Our Ref: WA/47/26/AOO

Section 106 Town and Country Planning Act 1990
Application for Approval of Details to Satisfy an Obligation

Application to approve details required under the Section 106 dated 28.07.2022 linked to WA/68/20/OUT in relation to Part D Clauses 4.1 and 4.2 (Public Open Space and Play Areas).
Land West of Tye Lane Walberton

drawing no: BDWS23688 20 Sheet 2
scale: 1:500@A1
drawn: LS checked: DKM

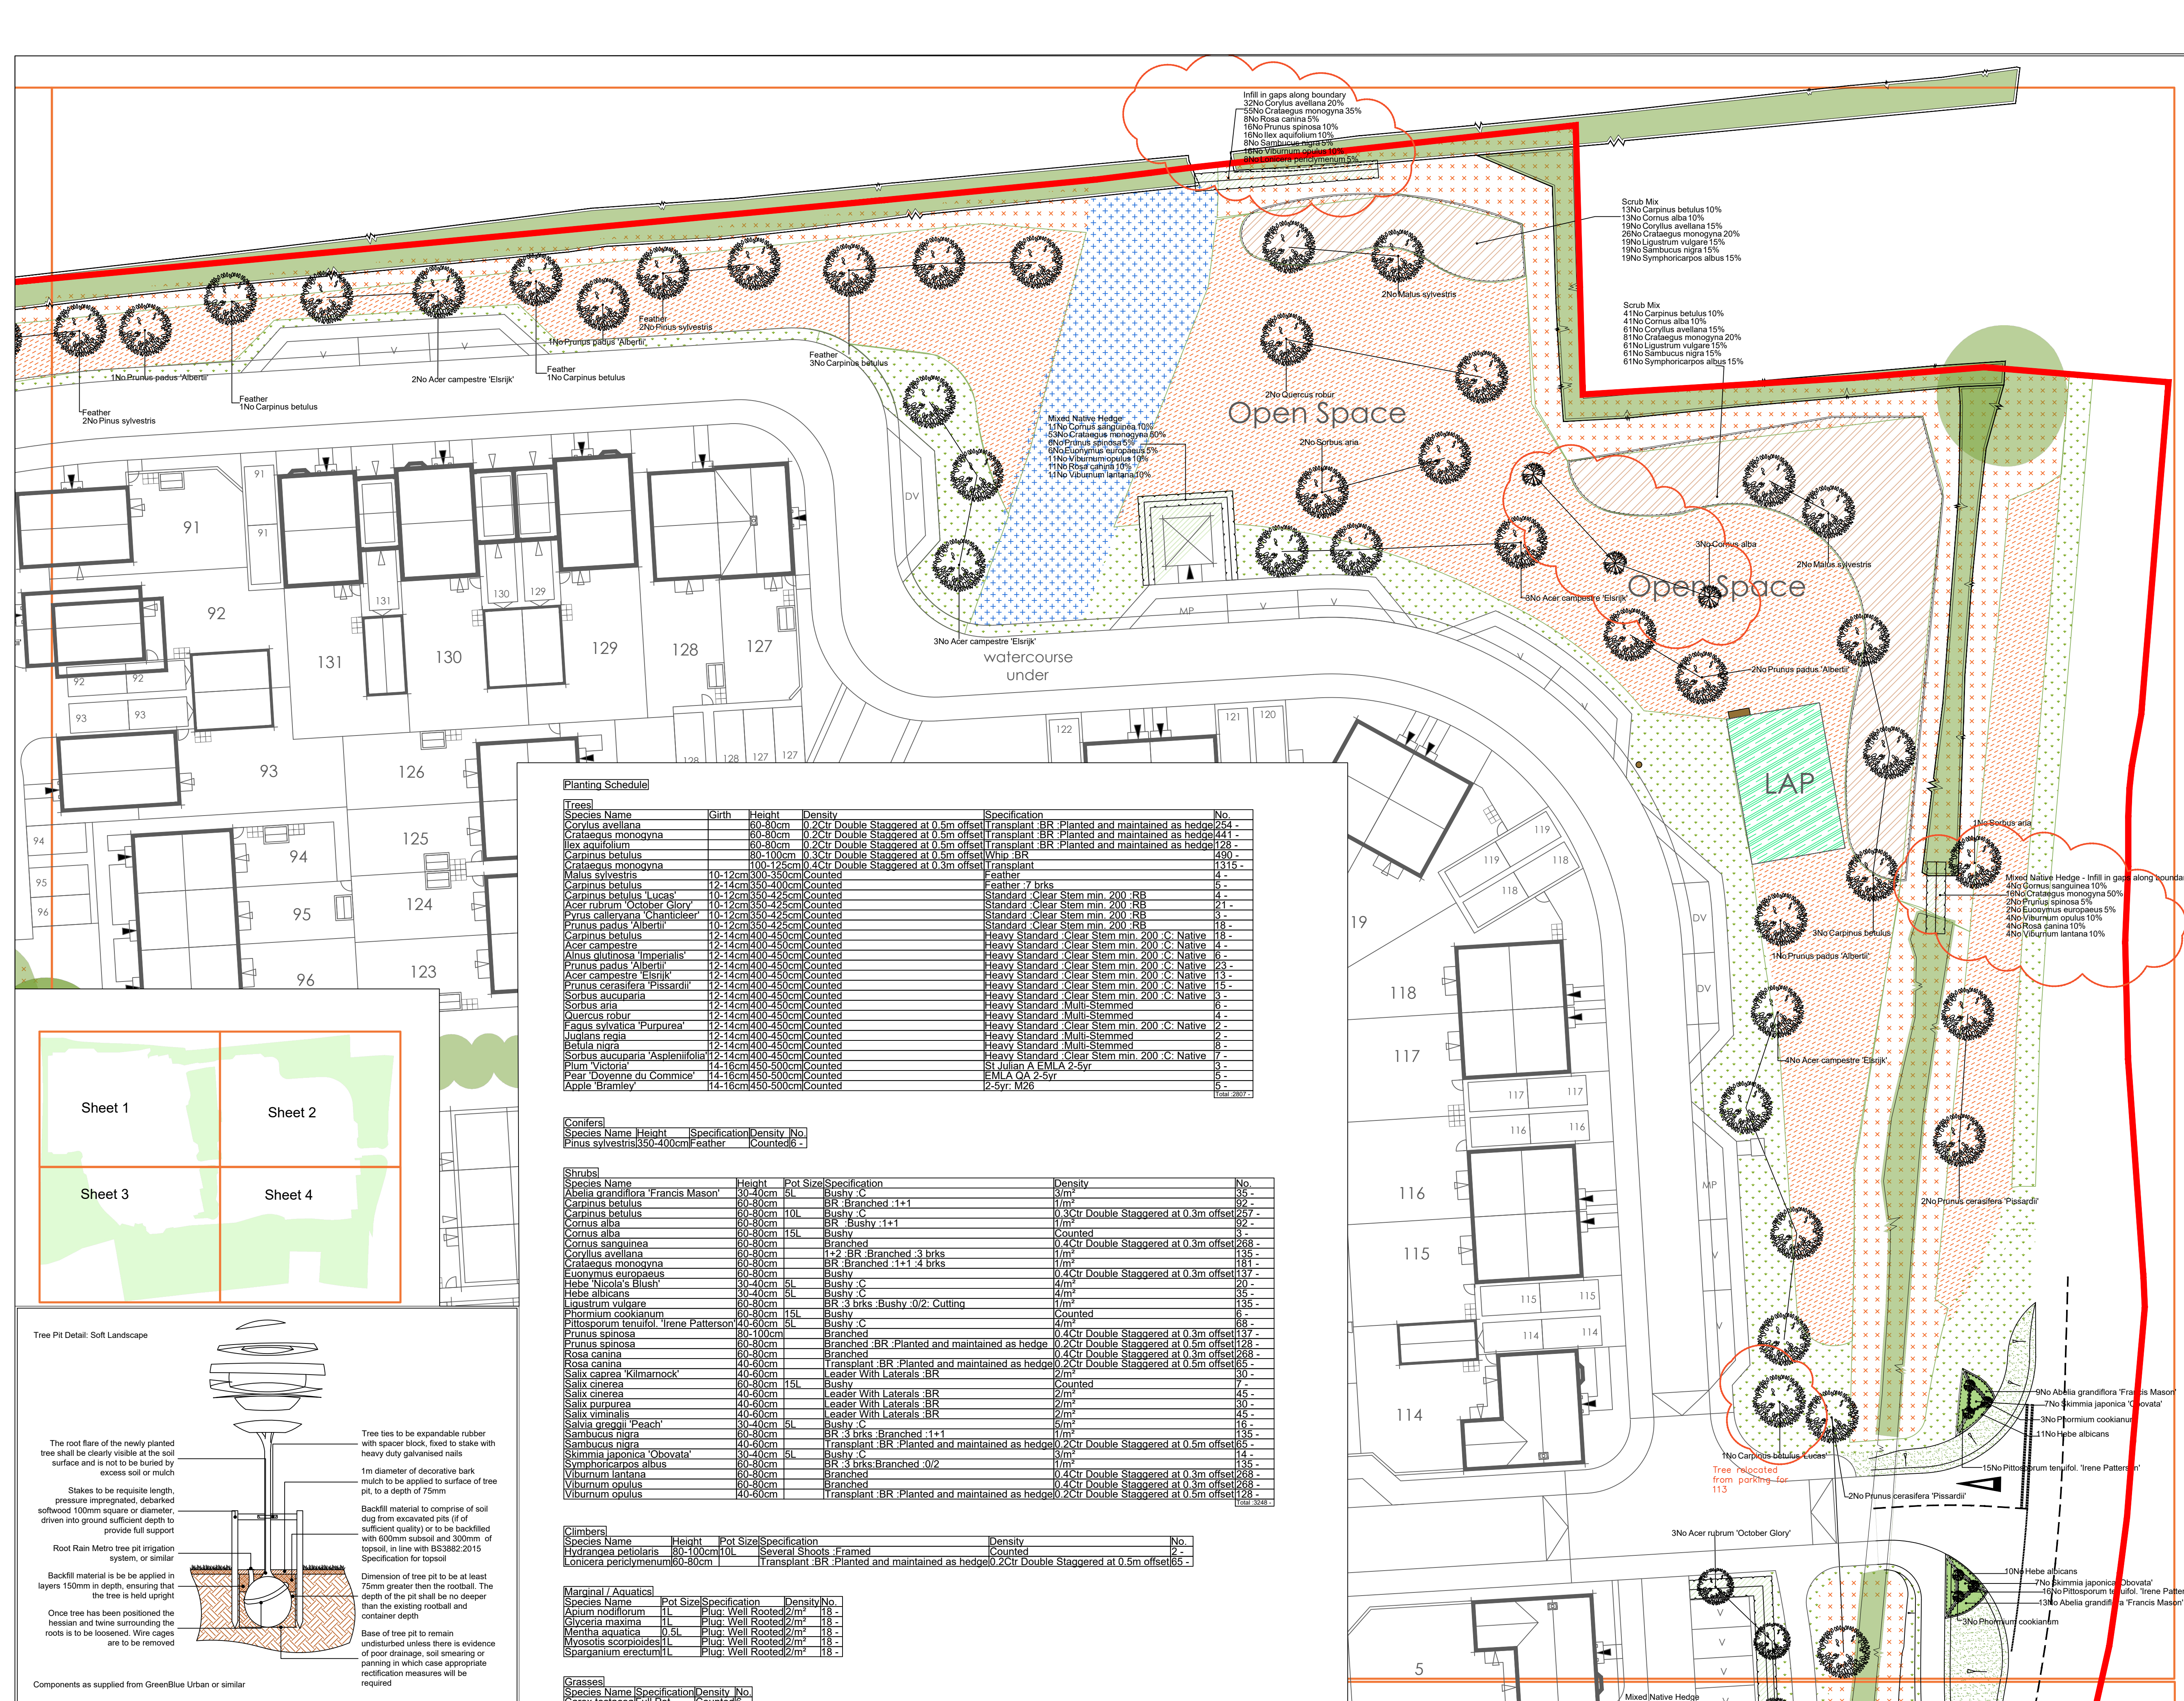
This proposal only allows for 1 no. formal play area, the LEAP. The LAPS would revert to areas of grass, with a bench and bin for convenience. Therefore, the public open space and play area are not of sufficient quality.

To revert the LAPs to simple patches of grass would not accord with the requirements of the SPD and this would not be appropriate or acceptable. Although a grass surface is an acceptable play surface, and a bench and bin are important amenities, they do not constitute play equipment. There would be nothing engaging for different ages and abilities, it would not meet the needs of the community, nor would they encourage risk and challenge. Overall, turfed areas would be visually read as open space, not a well designed play space.
